Development Control  
Ribble Valley Borough Council

**Re: Planning Application 21/0269**

**Address: 6 The Arches Whalley BB7 9SG**

**Description: Internal alterations and change of use from art gallery (class F) to ground floor shop unit (class E) and first floor flat (class C3).**

Proposed Site Plan 1:200

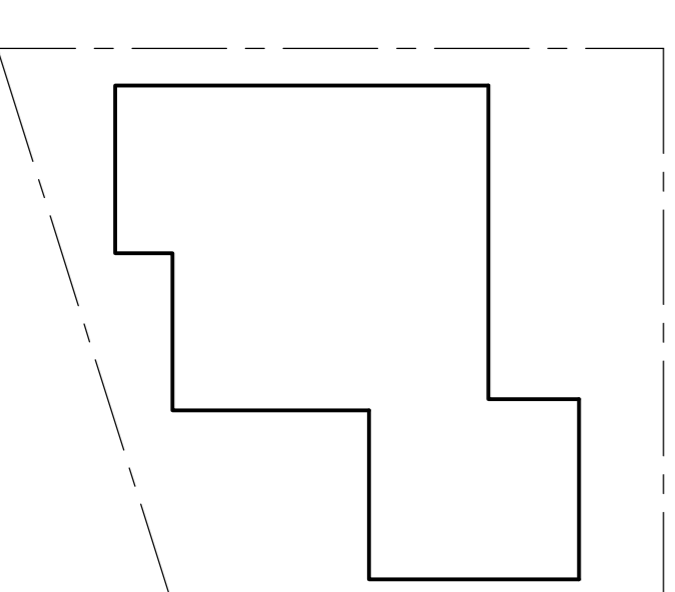
Whilst no details have been provided it is expected that the off-street parking will be allocated as 1 space for each for the shop unit and flat.

Due to the dual change of use nature of the application it is expected that 2 charging points for electric vehicles shall be included with-in the development to promote sustainable modes of transport with 1 point being allocated to each element of the development. This shall be fitted in line with the DfT guidance regarding Electric Vehicle Charging in Residential and Non-residential buildings, which states :- charge points must have a minimum power rating output of 7kW, be fitted with a universal socket that can charge all types of electric vehicle.

**1) Electric vehicle charging points.**

All garage facilities on off street parking shall include provision of an electrical supply suitable for charging an electric motor vehicle.
